Ribble Valley Borough Council
Council Offices
Church Walk
Clitheroe
Lancs
BB7 2RA

**Application Reference: 3/2026/0214 - Full Planning Application: Erection of 26 no. Affordable Dwellings with Associated Access, Gardens, Parking and Landscaping.
Land at Albany Drive, Copster Green, Ribble Valley**

- 1.1 Further to correspondence dated the 4th June 2026, outlining the Council's reluctance to support Planning Application 3/2026/0214 at Land off Albany Drive, Copster Green, please accept this supplementary letter as a response to the issues and objections raised. This letter has been produced on behalf of Pringle Homes ('Pringle' or the 'applicant') by Maybern Planning and Development Limited ('Maybern').

Drawn: W.L.	Checked:	Scale: 1:500	Date: JAN 2026
Job No: 24-133	Drawing No: PL01	Rev:

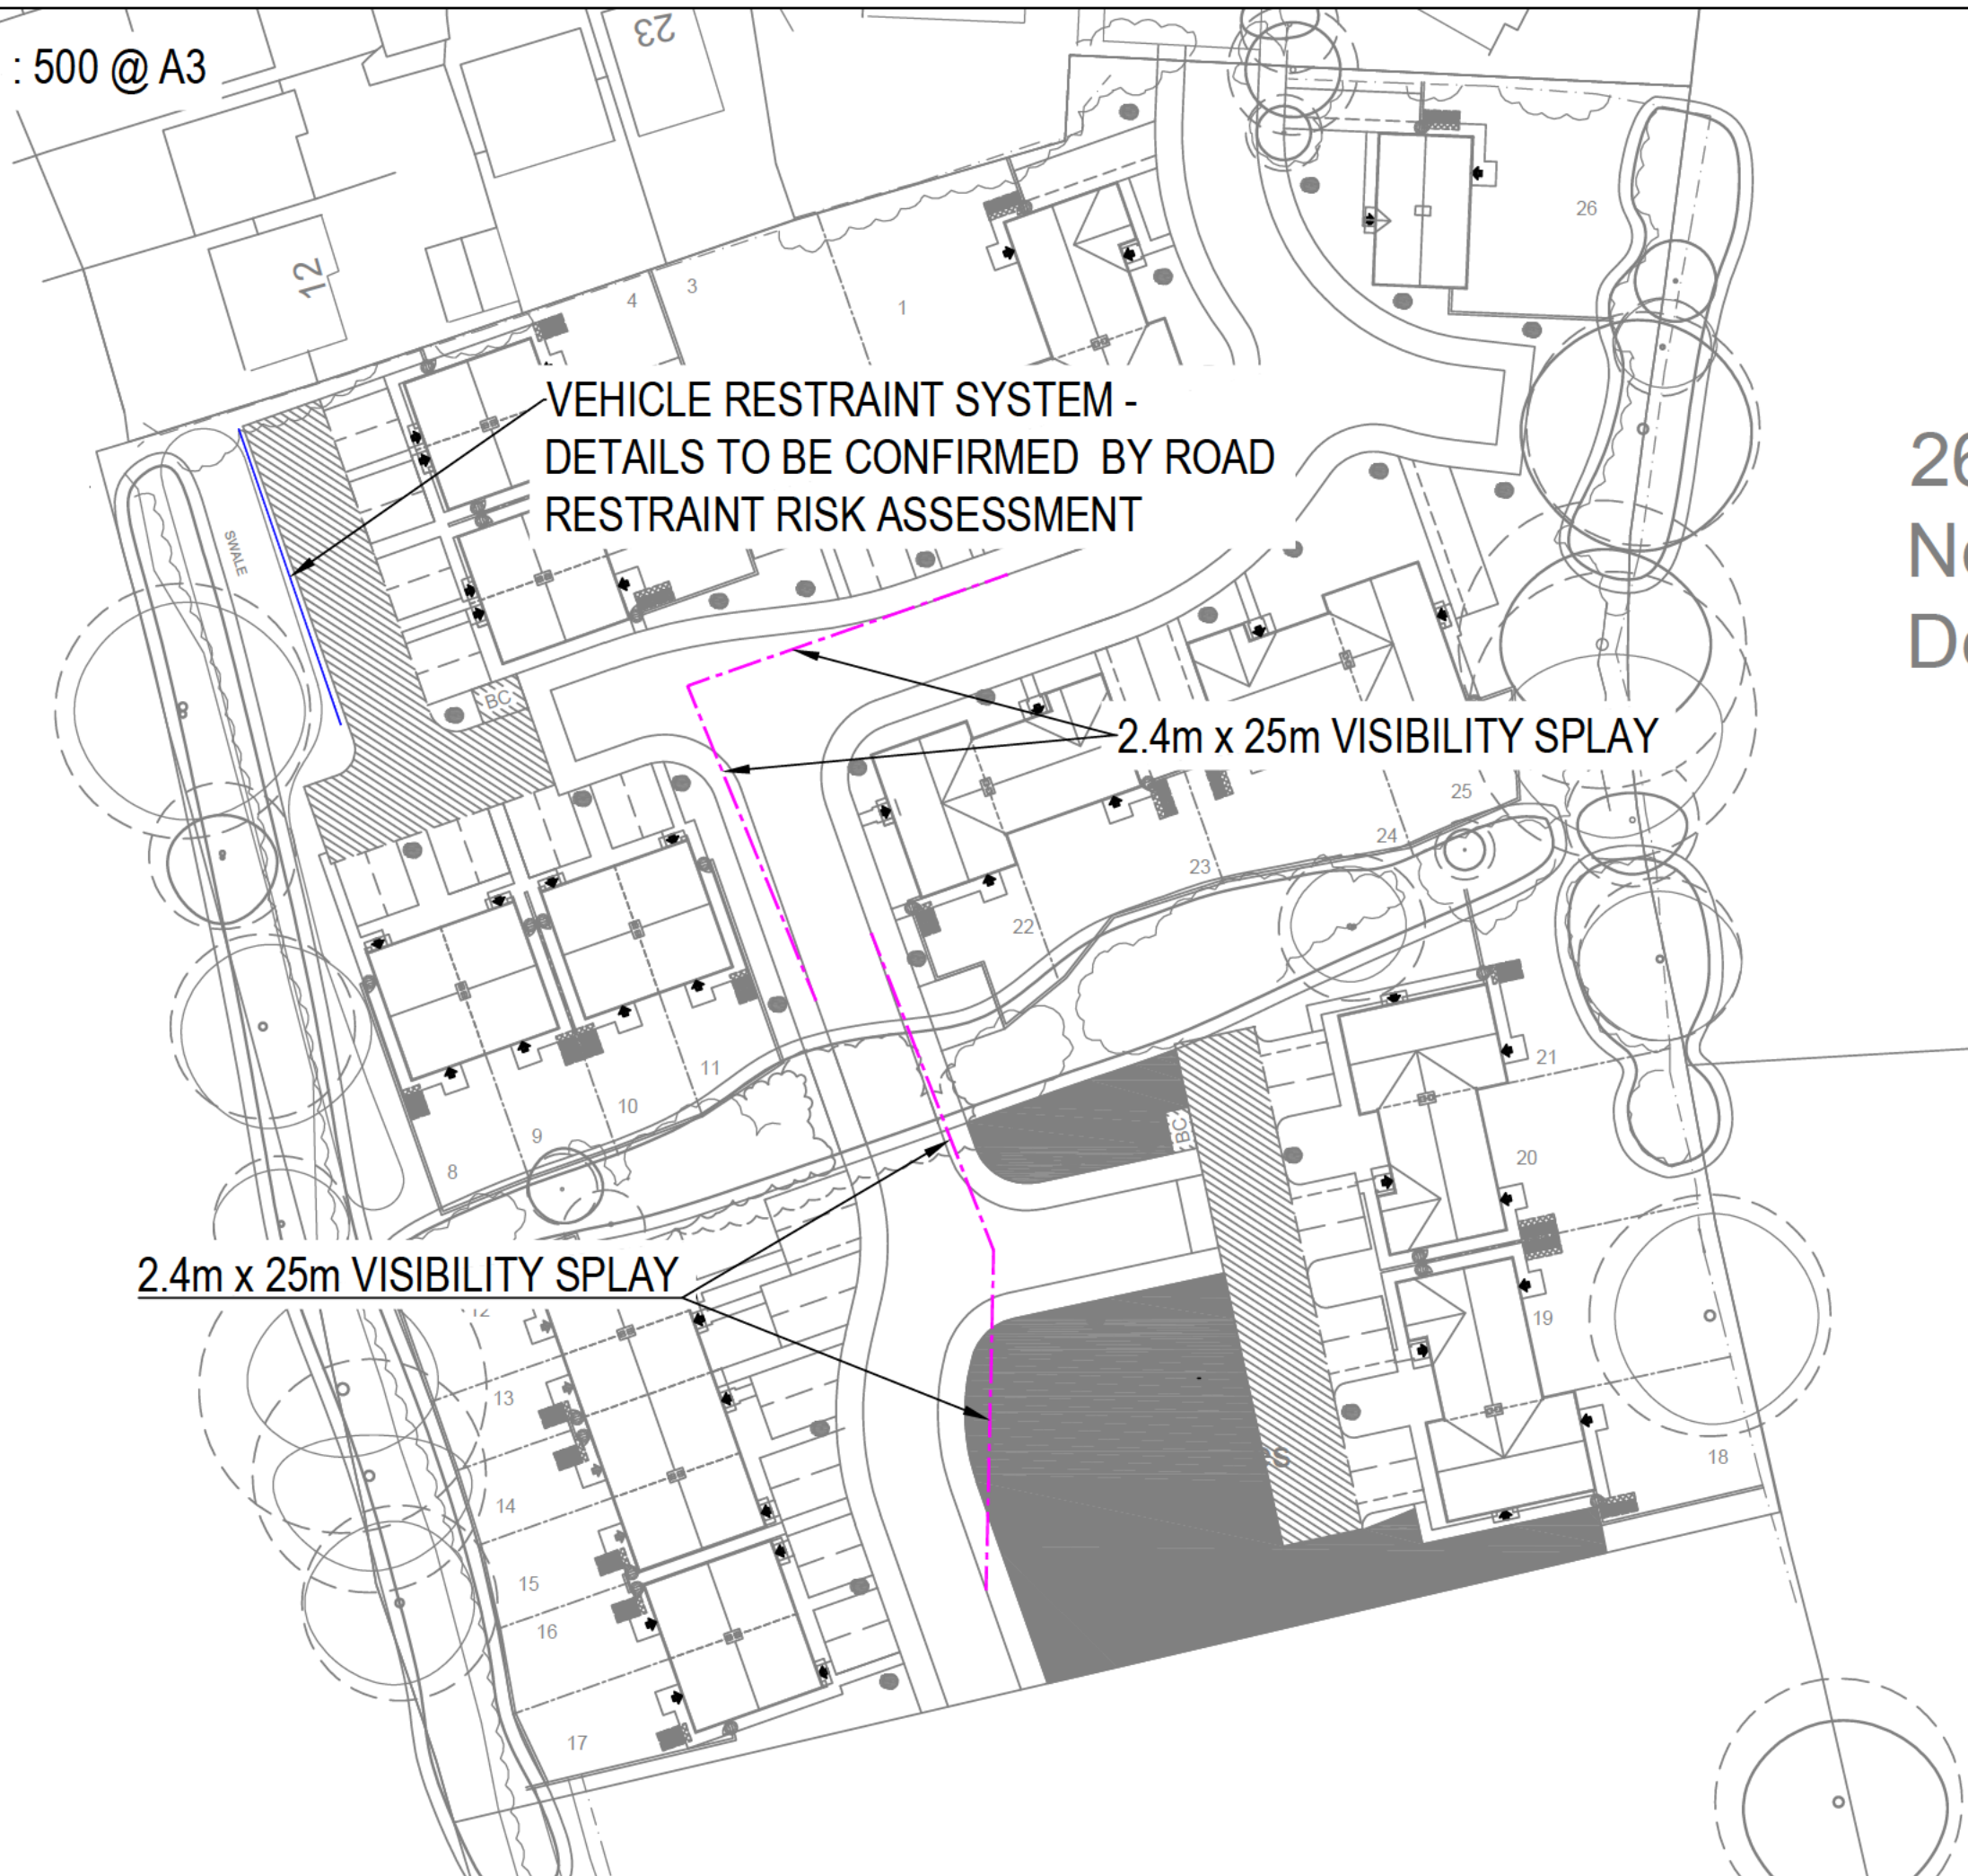
- 1.24 Visibility splays are confirmed as acceptable. It is apparent that indicative landscaping was shown on the site layout plan within the visibility splay to the south from the side arm of the internal access. However, the trees shown on the more detailed landscaping plan show trees set to the rear of visibility splays. An updated Landscaping Plan is currently being prepared to reflect the associated revisions to the site layout, including changes to driveway widths and pathways.

- 1.25 Driveway widths and pathways are also amended (widened) to respond to LCC comments. As such, I also enclose the amended Proposed Site Layout Plan (ref 24-133 PL01 Rev D). These changes are also reflected within the wider planning pack which has been updated and provided in support of this supplementary statement.

SECTION A-A

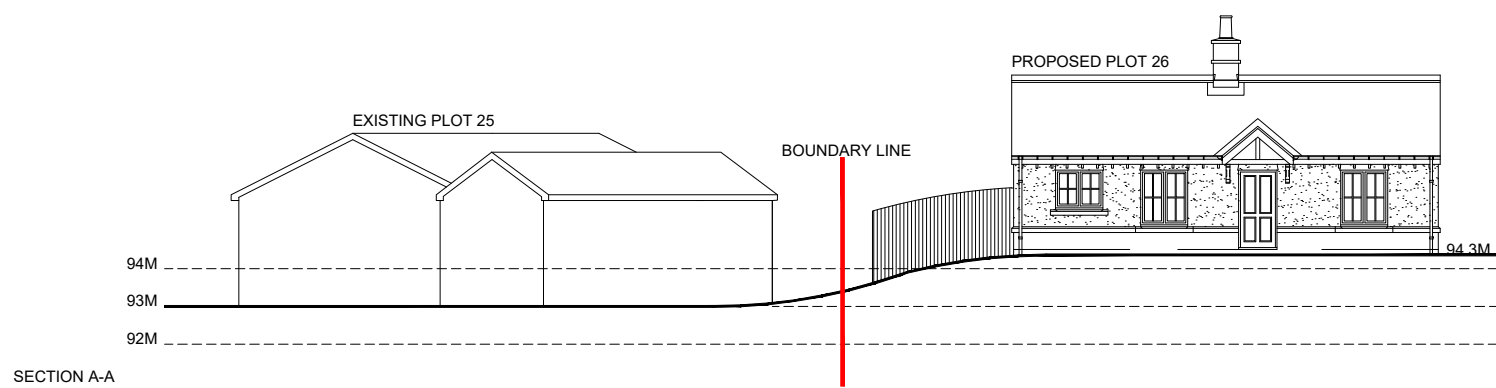
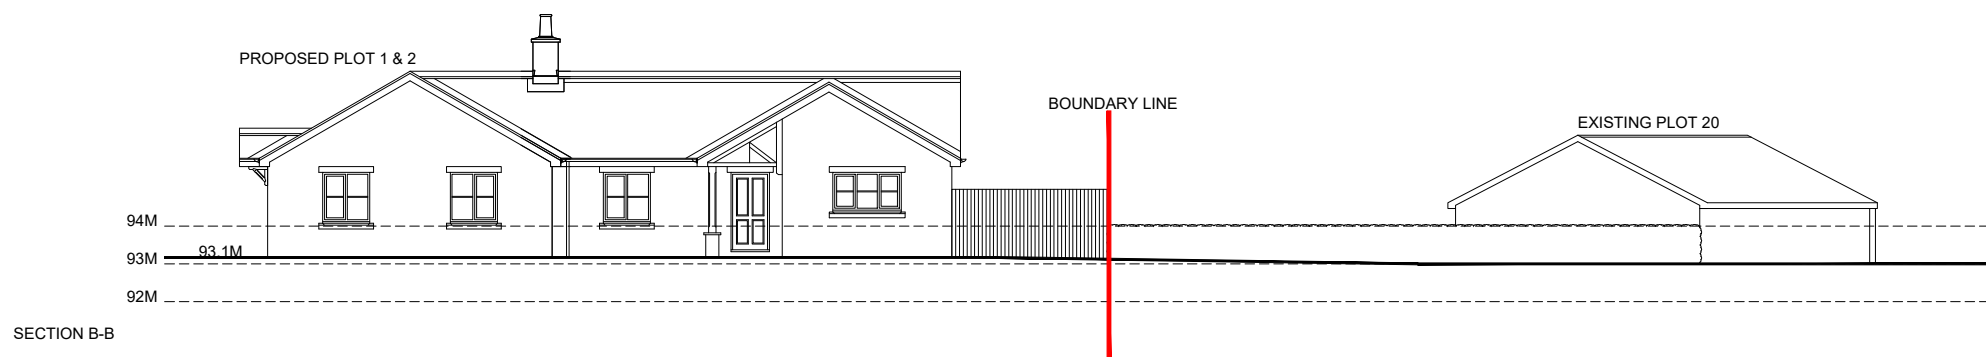
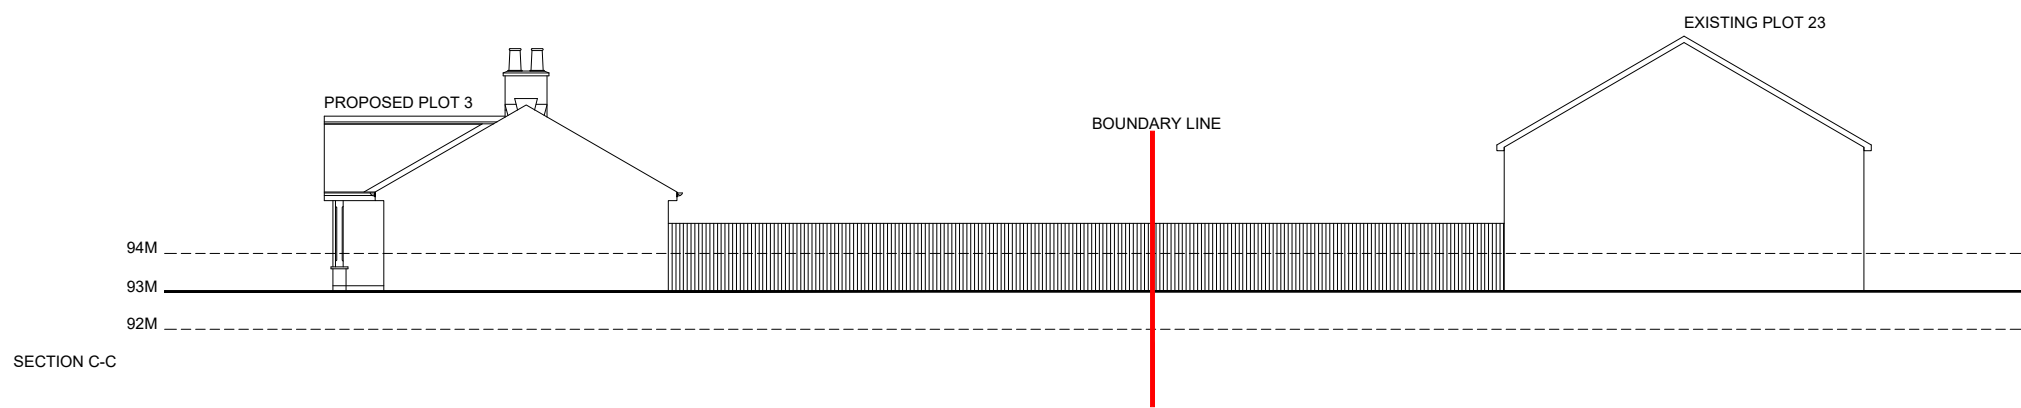
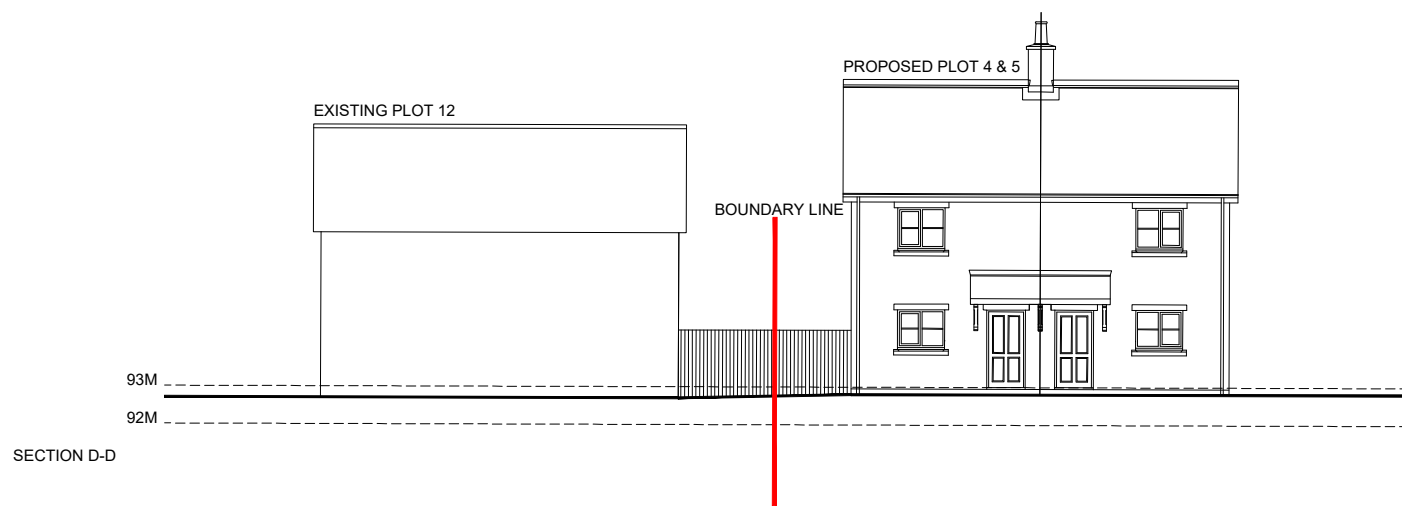
- 1.31 A Section and finished floor levels are provided for the site; both are provided through the provision of Site Section 24-133 SX01 Rev A.
- 1.32 With regard to the Lighting Assessment request; while the applicant is willing to have an assessment prepared, it has not been possible to instruct any such exercise. The Council has not provided formal comments from the EHO such that it could be scoped and the applicant's position on the matter is that the proposed scheme is of a very similar character to existing residential development that surrounds the site. It remains unclear as to the basis for these concerns and it is requested that the officer consider imposing a condition requiring a lighting scheme prior to the commencement of development.
